CITY OF ALBUQUERQUE

RE: Utility Trailer Sales
8201 Daytona Rd NW
Grading Plan Stamp Date: 5/14/18
Drainage Report Stamp Date: 5/14/18
Hydrology File: K09D026B

Based on the information provided in your submittal received on 5/16/18, the grading plan and drainage report are approved for Site Plan for Building Permit (only) with the following conditions:

ENGINEER'S SEAL VINCENT P. CARRICA P.E. #16212	UTILITY TRAILER SALES ALBUQUERQUE NM GRADING AND DRAINAGE PLAN	DRAWN BY LA
	DATE 4/20/2018 2017041-GRADING	SHEET # C2 JOB # 2017041

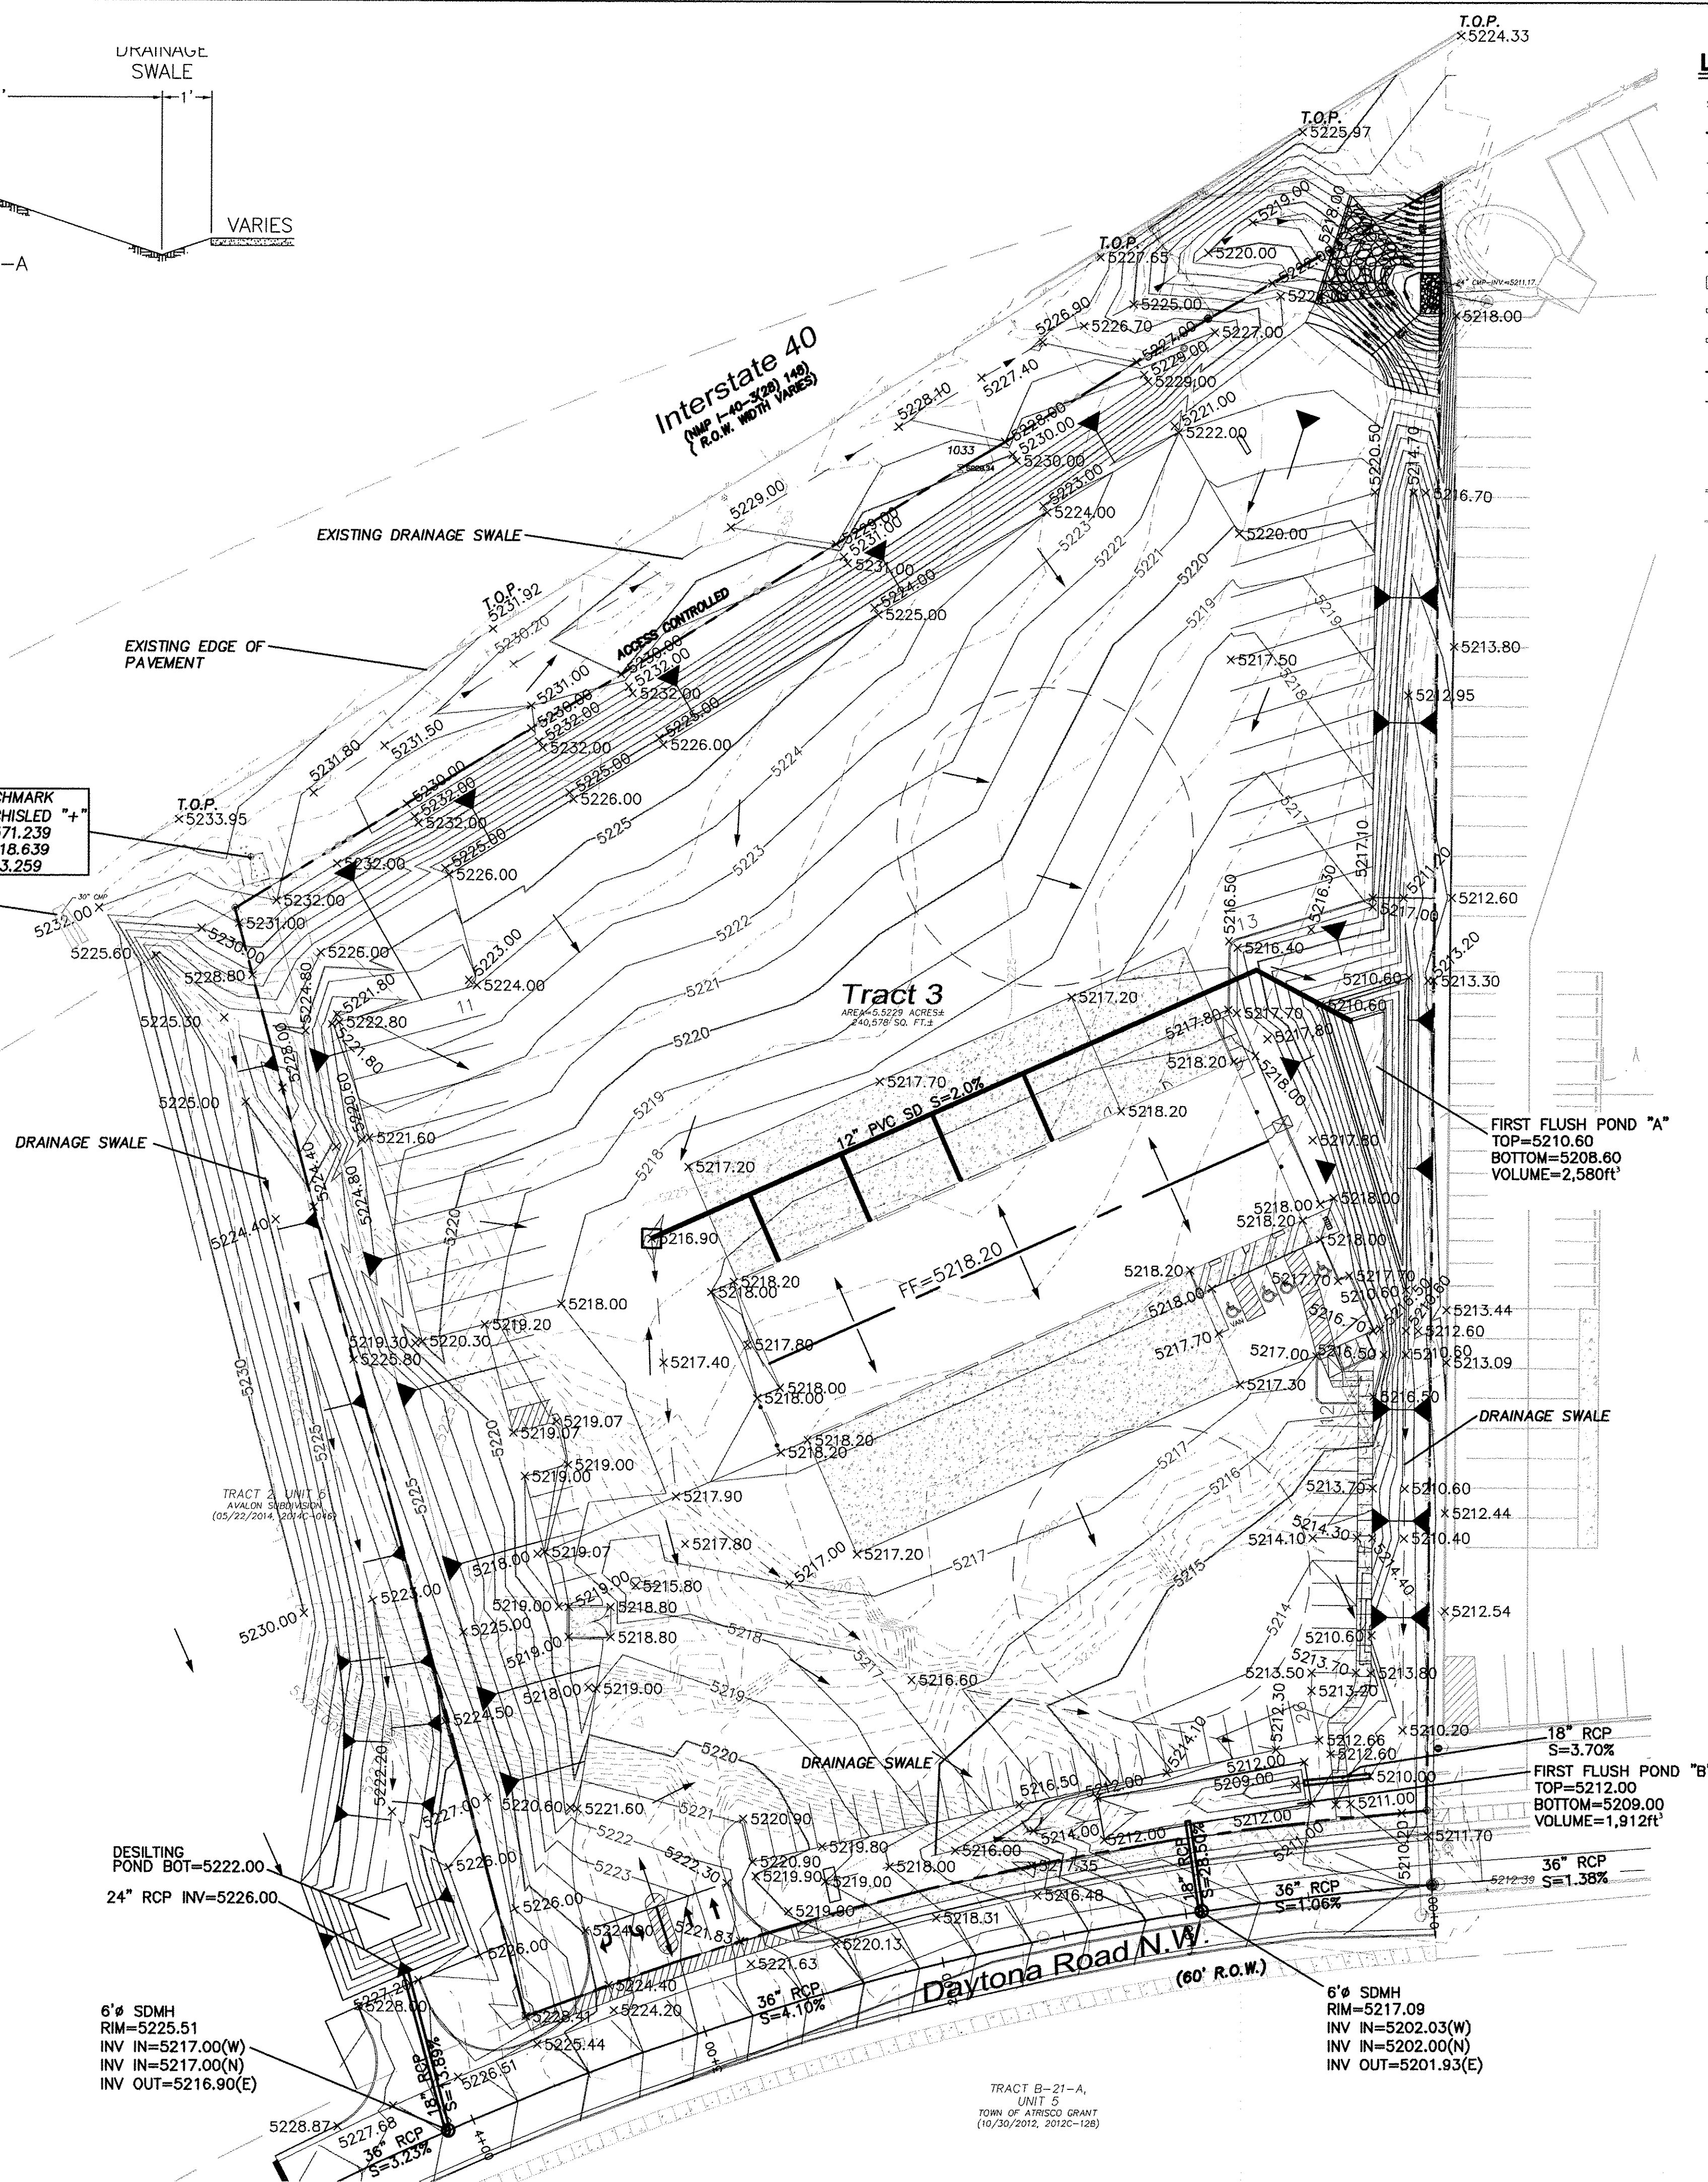
1. Label the grading plan as “Conceptual, not for Construction” or similar. This will be checked at DRB.
2. The pond and swale with an Agreement and Covenant and a Public Drainage Easement on Tract2 need to be included on the infrastructure list.
3. The Public Drainage Easement and the Agreement and Covenant on the NE corner of Tract3 need to be included on the infrastructure list.

4. The grading in the SE corner of the site does not support the proposed drainage pattern. For instance the contours and spot elevations do not indicate a swale along the property line, connecting the two first flush ponds. The SE corner is lower than the InvertOut of the adjoining pond riser (5012.00' vs ~5010.20'-5011.00'). The grading in this area will need to be reworked to ensure a clear flow path from Pond A to Pond B to the 18" RCP into Daytona. Pond B bottom and InvertOut will likely need to be lowered.
5. There are a few proposed spot elevations and contours across the property line onto Bruckner's property. Please correct to show no grading across the property line here. If this work is required, written and signed permission will need to be obtained from the property owner.
